Re: Albuquerque ER & Hospital
4315 Wyoming Blvd. NE
Traffic Circulation Layout
Engineer's Stamp 11-09-21 (G19-D004D)

Based upon the information provided in your submittal received 11-16-21, the above referenced plan cannot be approved for Building Permit until the following comments are addressed:

SP-2

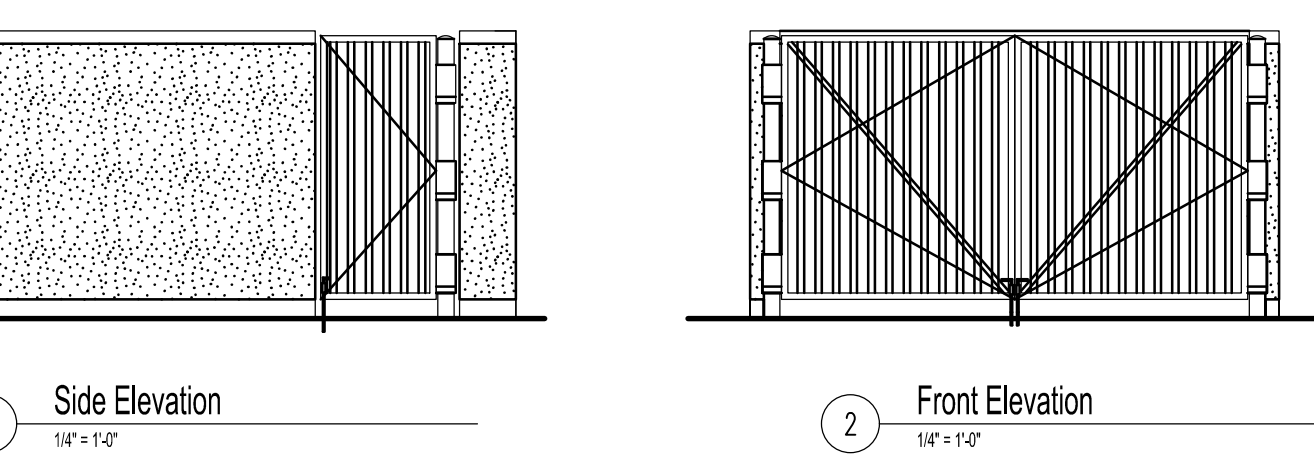
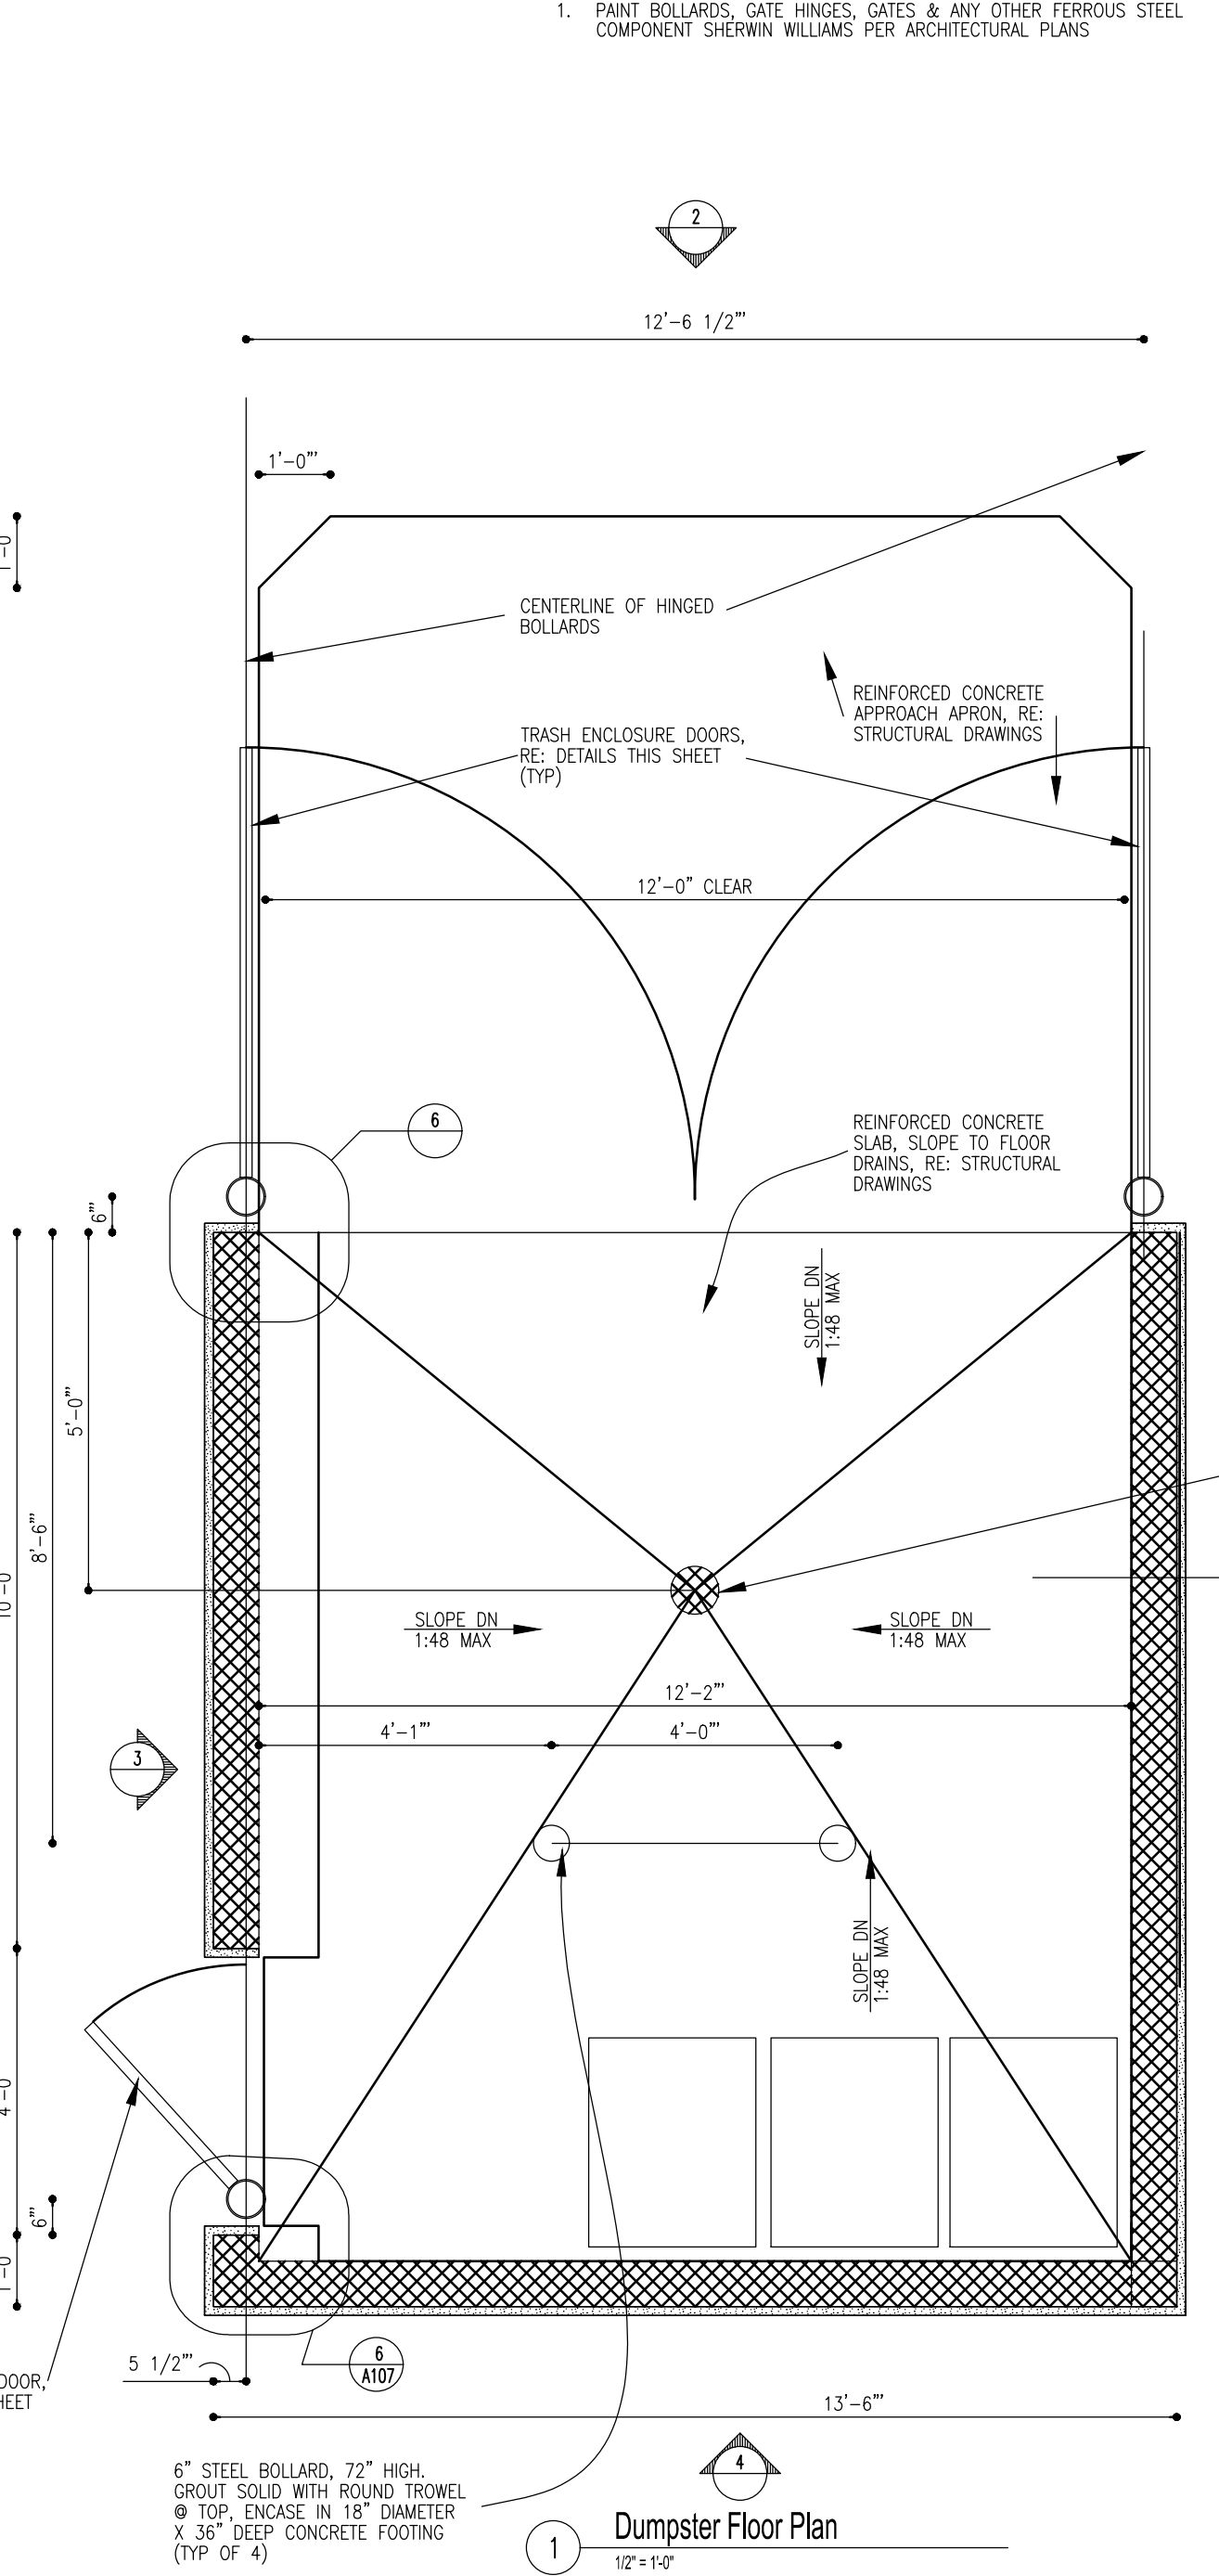
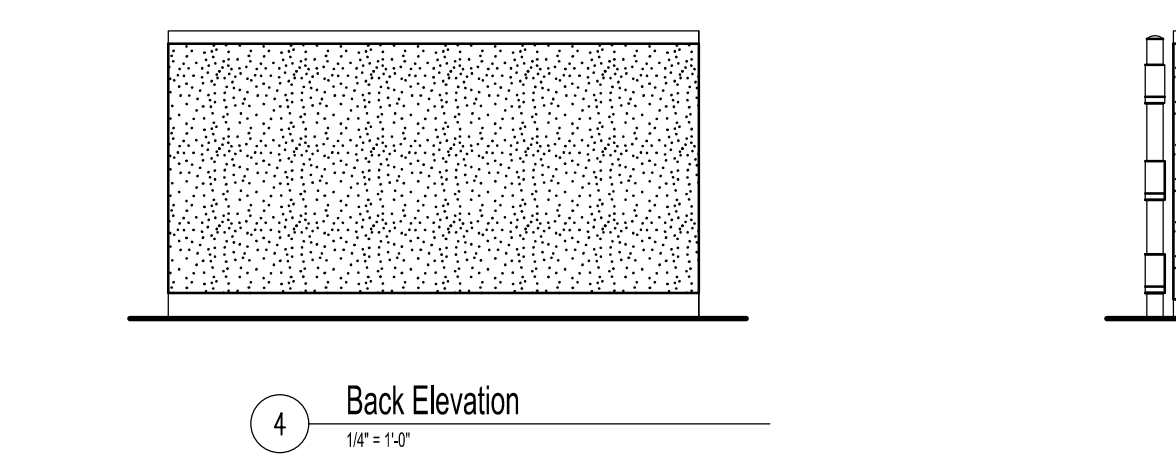
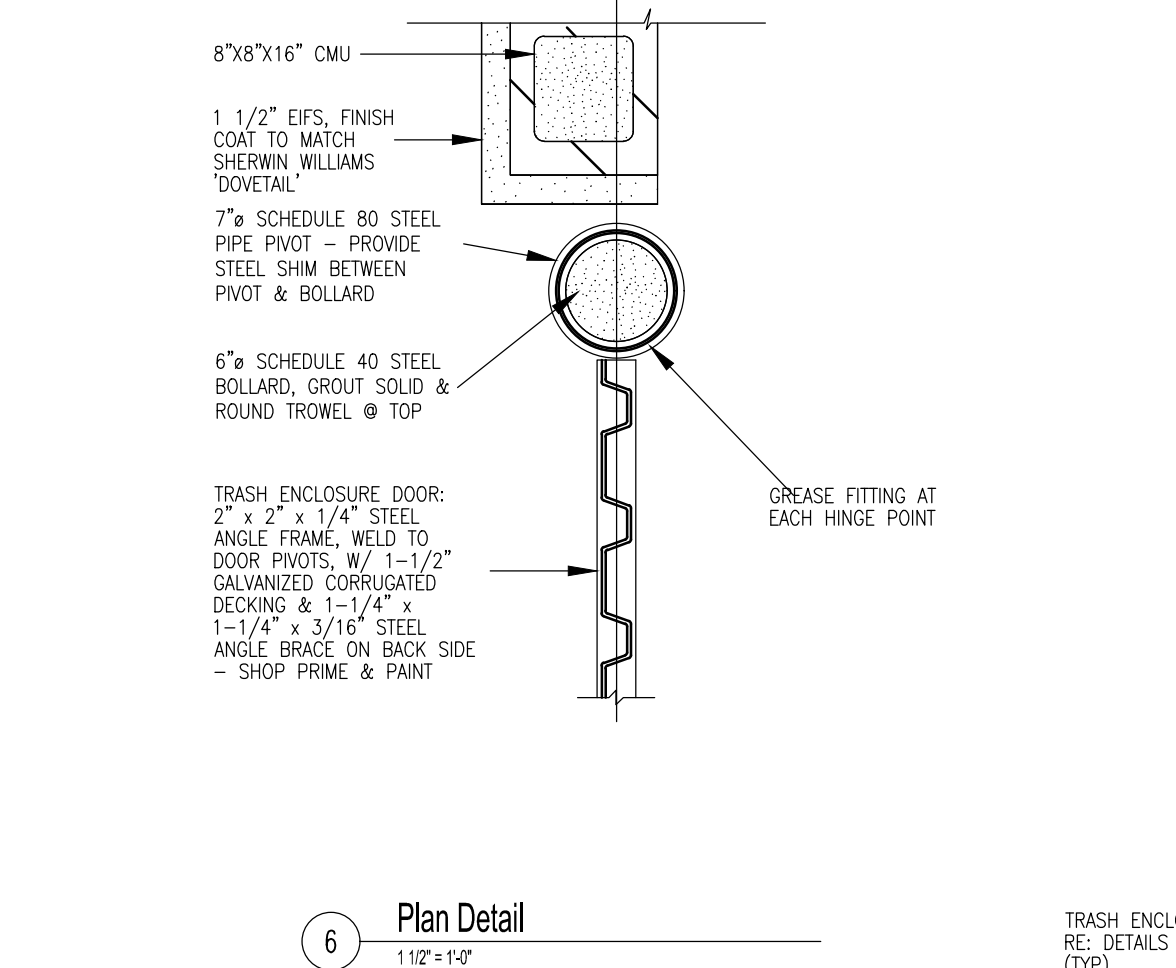
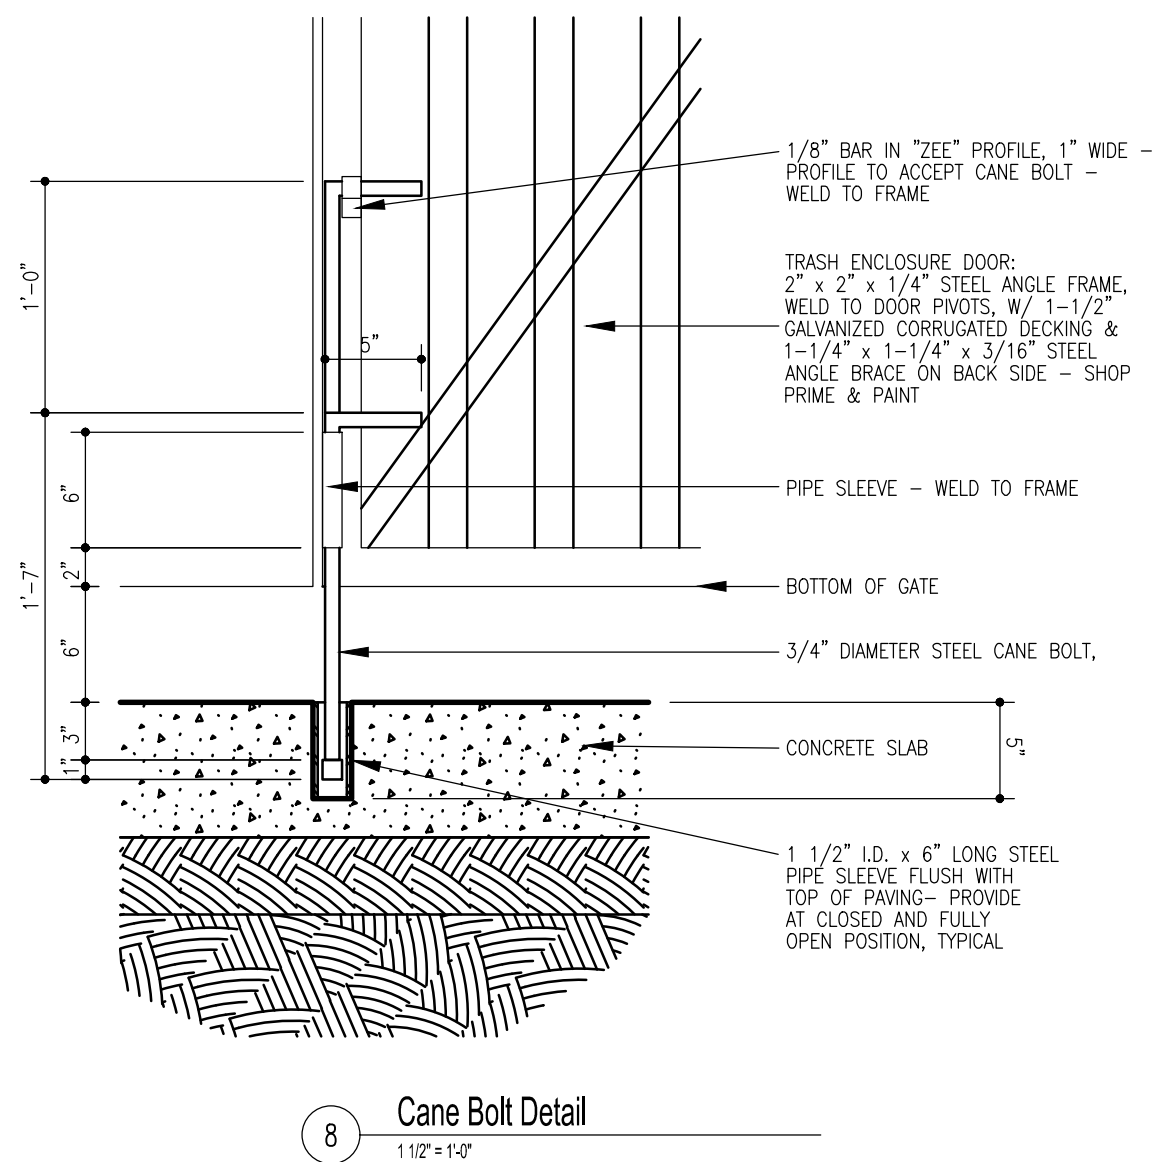
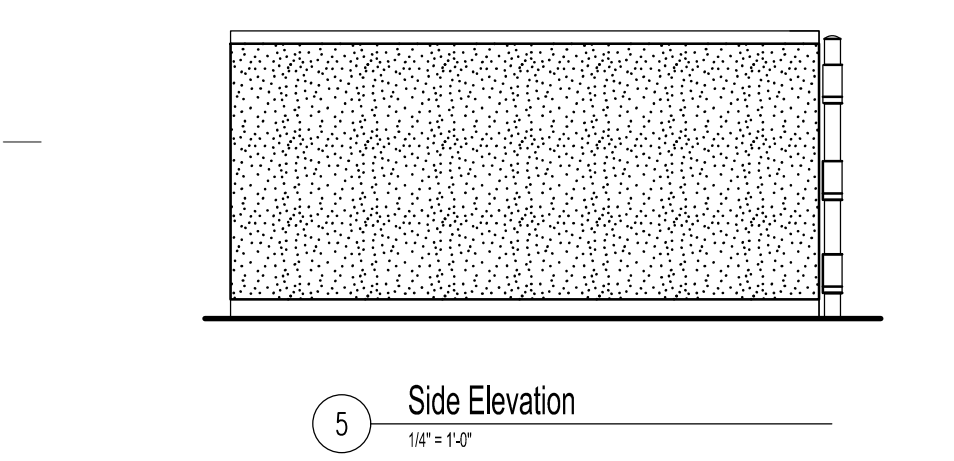
1. Key note 18: Proposed driveway access Ramp on-site plan is not per COA standard DWG. Please modify the site plan.
2. Site plan showing that ADA Van access aisle is 8', but the details sheet shows 7'. Please address this concern.
3. The ADA accessible spaces must include an access aisle. Van accessible aisles should be 8ft wide; all others should be 5ft wide.
4. ADA Van accessible aisle: Per DPM, a 6 ft. wide ADA accessible pedestrian pathway is required from the ADA parking stall access aisles to the building entrances. Please clearly show this pathway and provide details.
5. ADA Parking space: It appears there will be a conflict between the overhang vehicle and the proposed ADA sign. Please address this concern.
6. Provide Fire Marshal Approval.
7. Provide a copy of Approved Preliminary Plat. (This is a condition for approving TCL)
